From: Dann, Fraser <fraser.dann@wsp.com>
Sent: 11 August 2020 14:33
To: Kate Mansell
Cc: Brooks, John
Subject: Interchange 26 - Yorkshire Water comments - 2020/91468 and 2020/91488

I'm contacting regarding the Yorkshire Water (YW) comments that have been received to the above applications. They are generally the same on both applications therefore this response is submitted to both. All information submitted to both applications can be accessed via the following link for information purposes and to assist YW and any other relevant consultees. <https://spaces.hightail.com/space/nkykxkF9oA> Please could this email also be submitted to the LLFA in respect of these applications for completeness?

Dwg Title: **S38 DRAINAGE LAYOUT
SHEET 1**

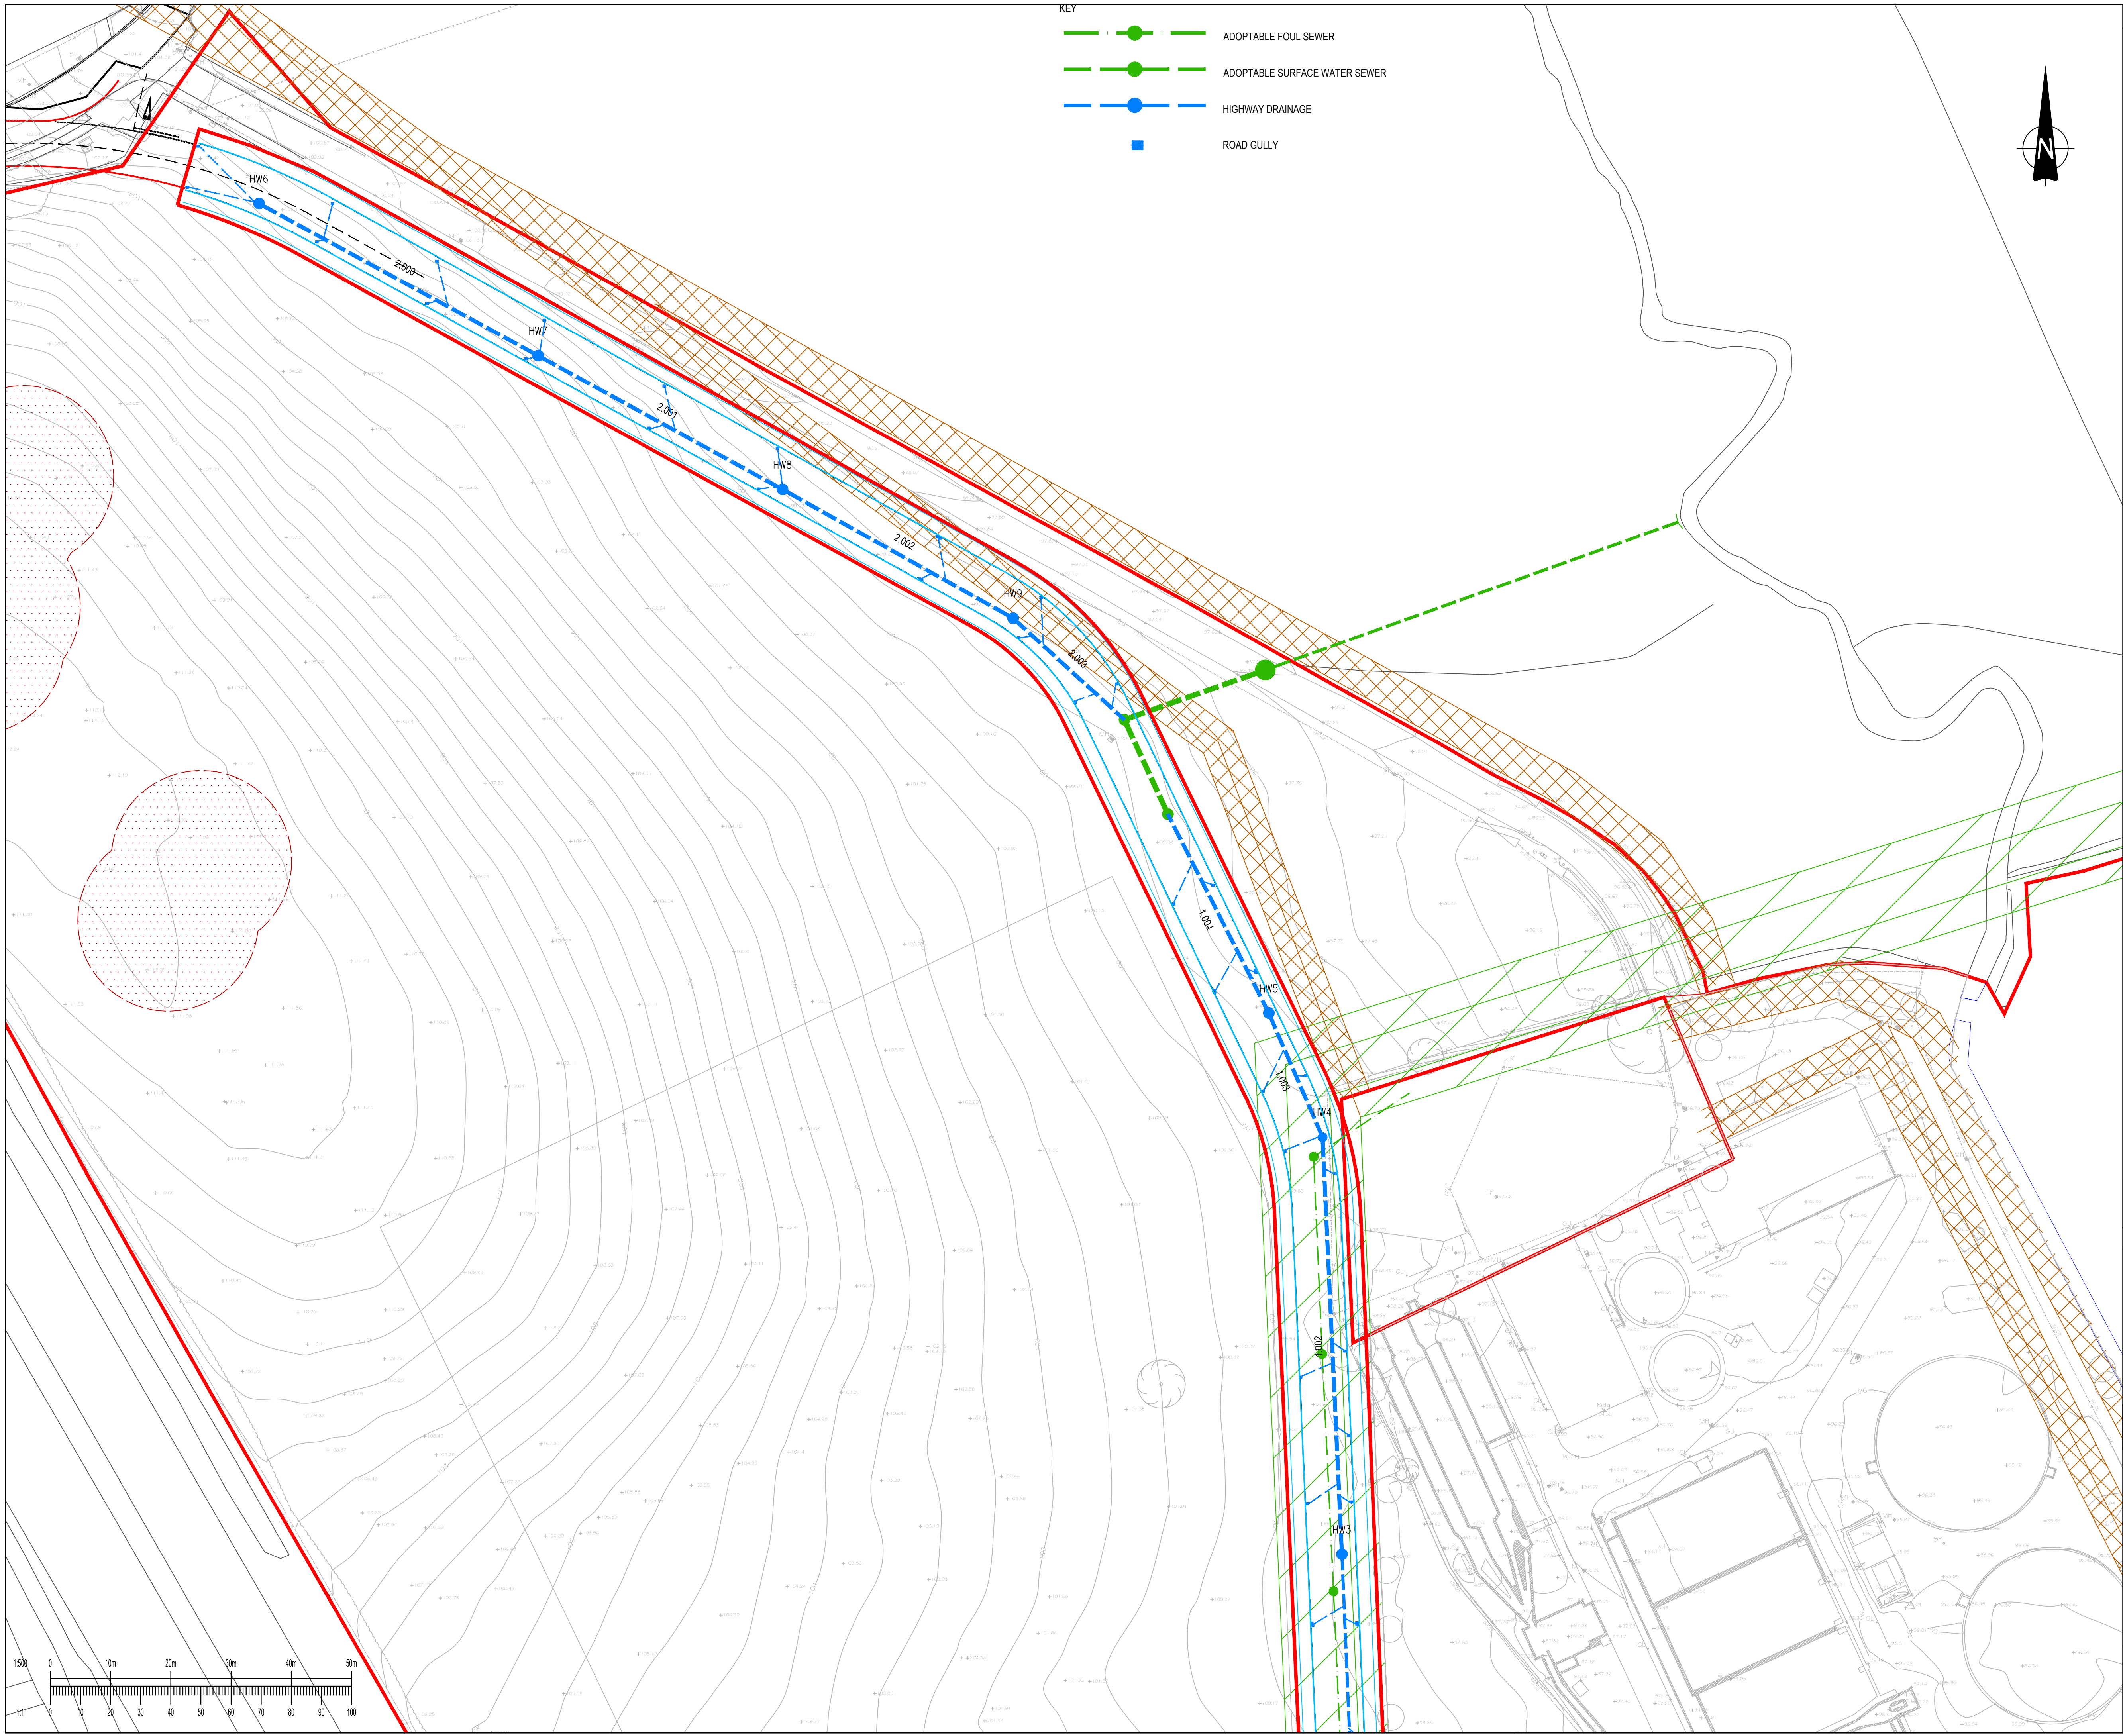
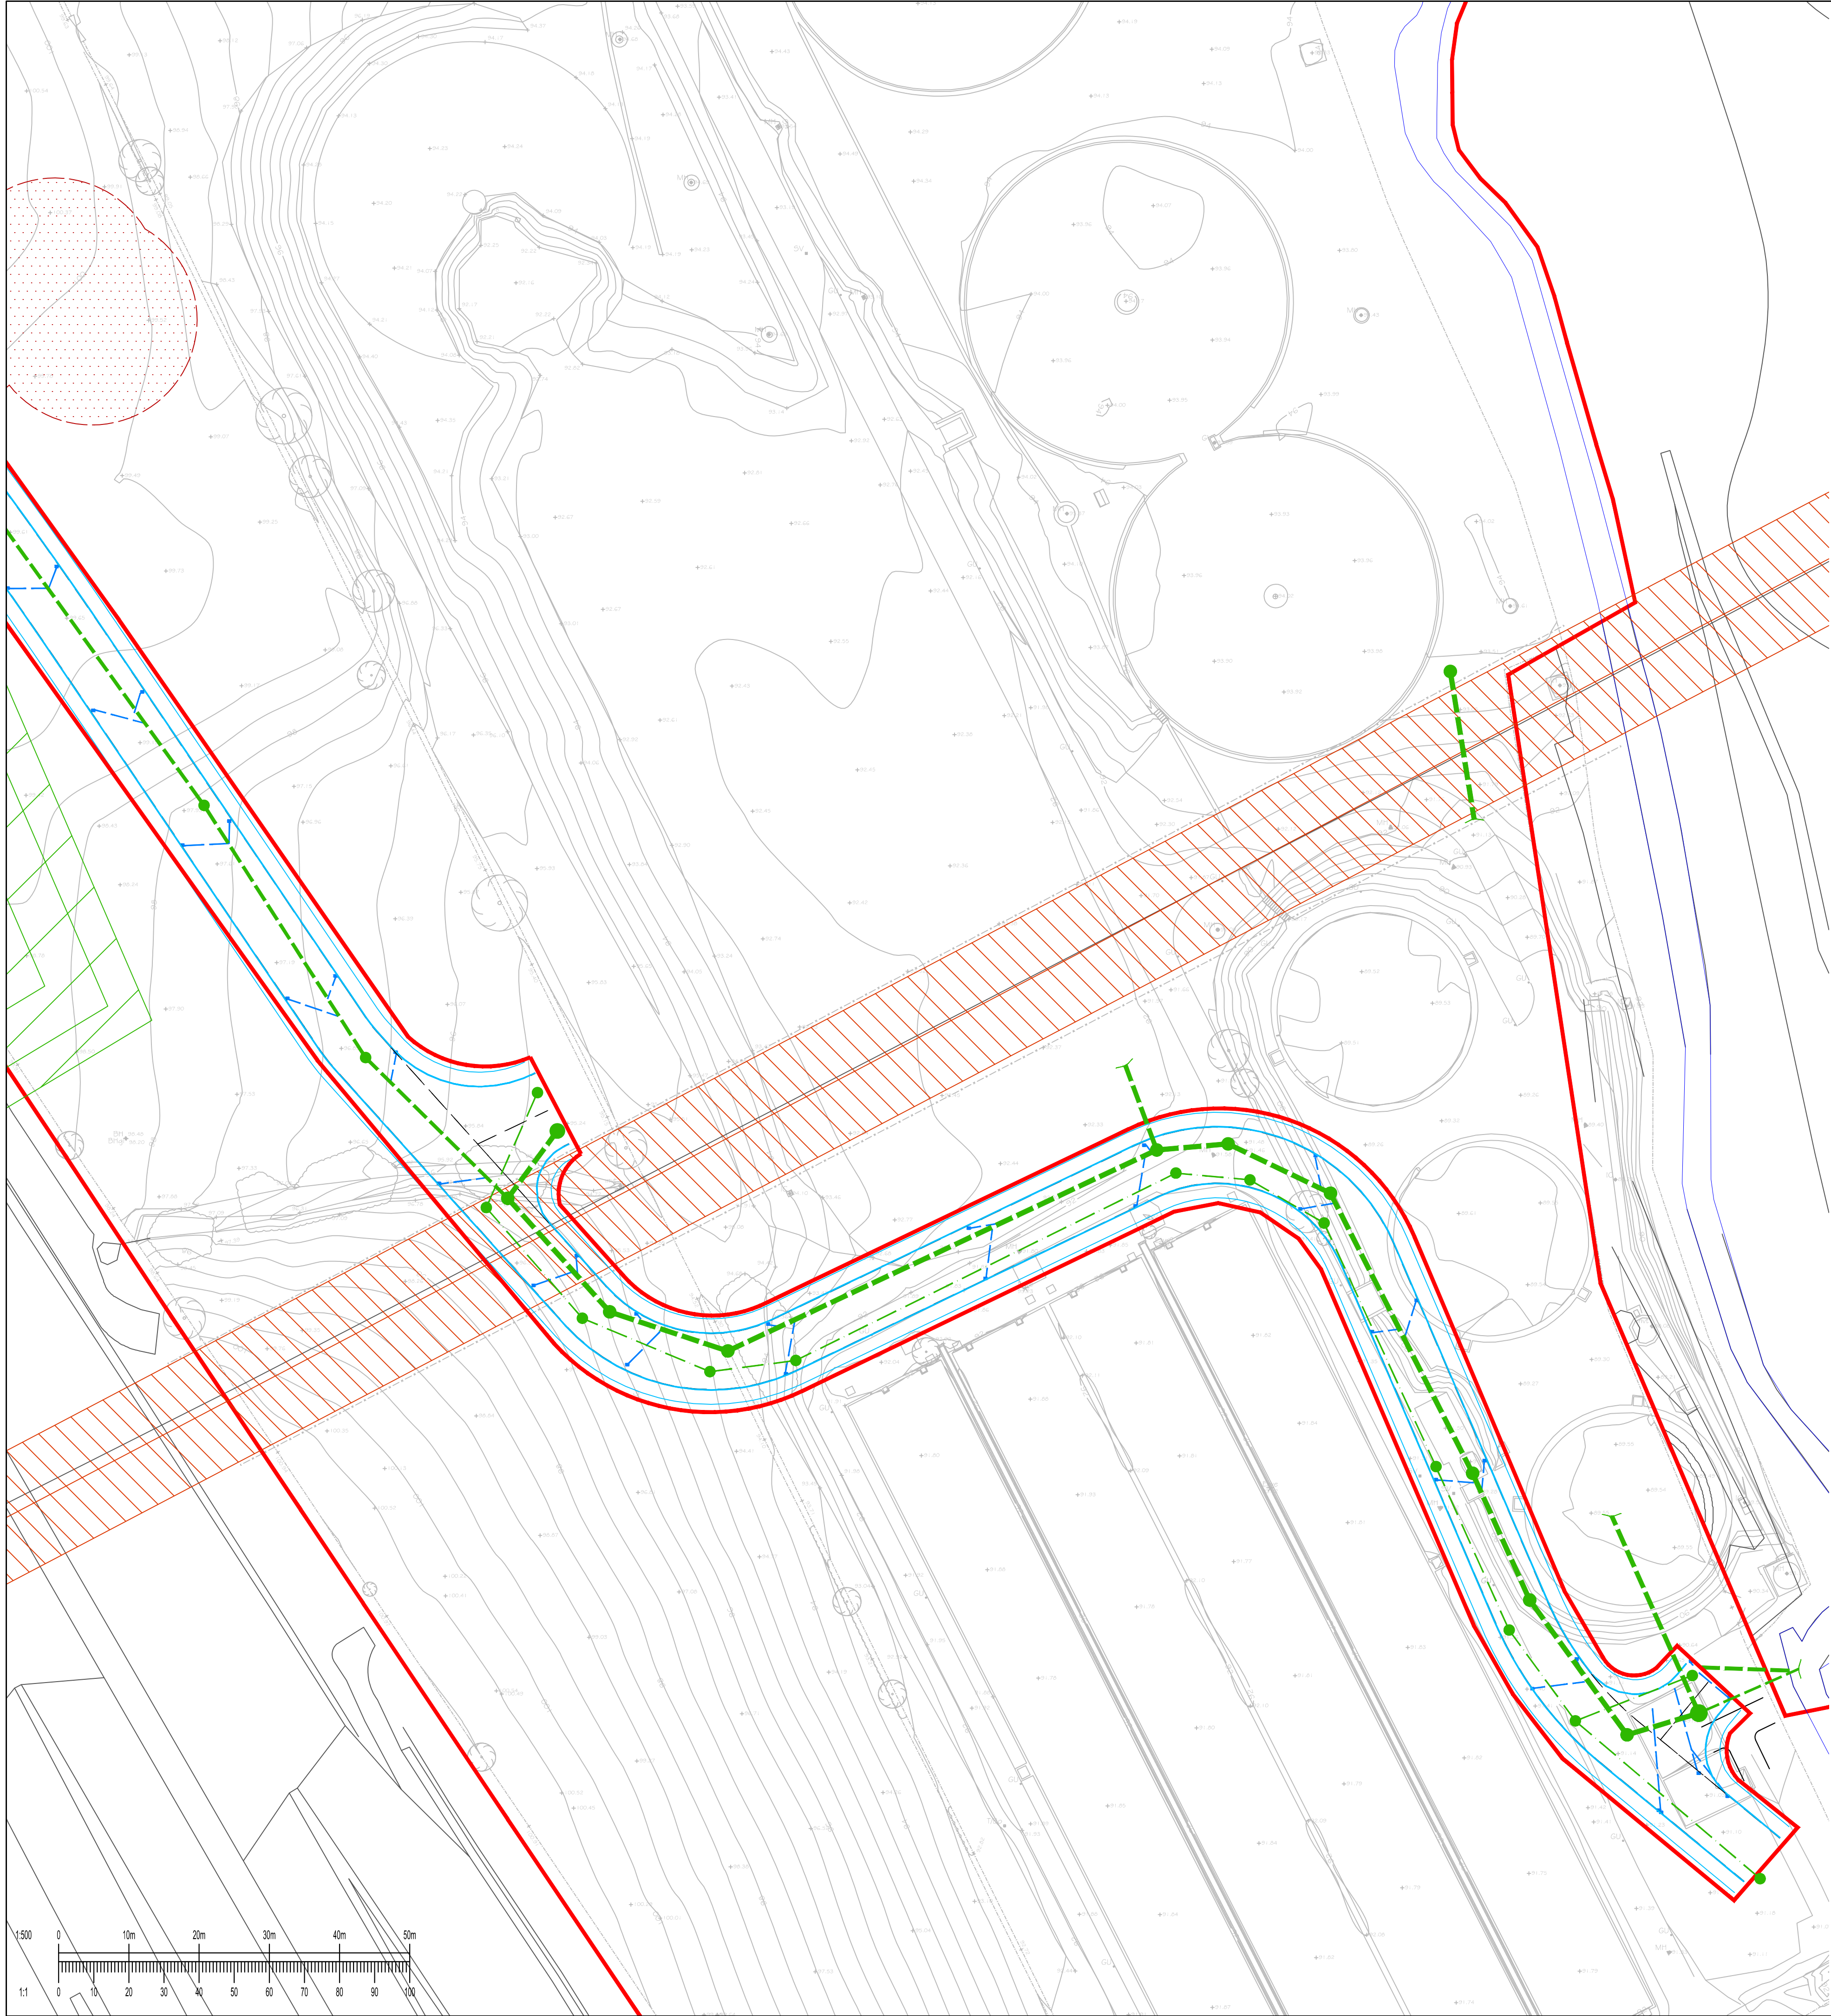
However, in respect of the other conditions, and the RM submission, the comments state *"From the submitted drawings, the public sewerage infrastructure crossing the site has not been accounted for, in particular, access to the Combined Sewer Overflow (CSO) to the north west of the site. The clean water infrastructure may also be affected by the development proposals; further information is required."* The YW Sewer Overflow is within the area of land to be retained by YW and hence will not be negatively impacted by the proposed development (see screenshot below). The access to the overflow will therefore be as existing through the YW compound. Curtins have reviewed the other areas of the site which could potentially be impacted by the proposed development and did not identify any other issues either.
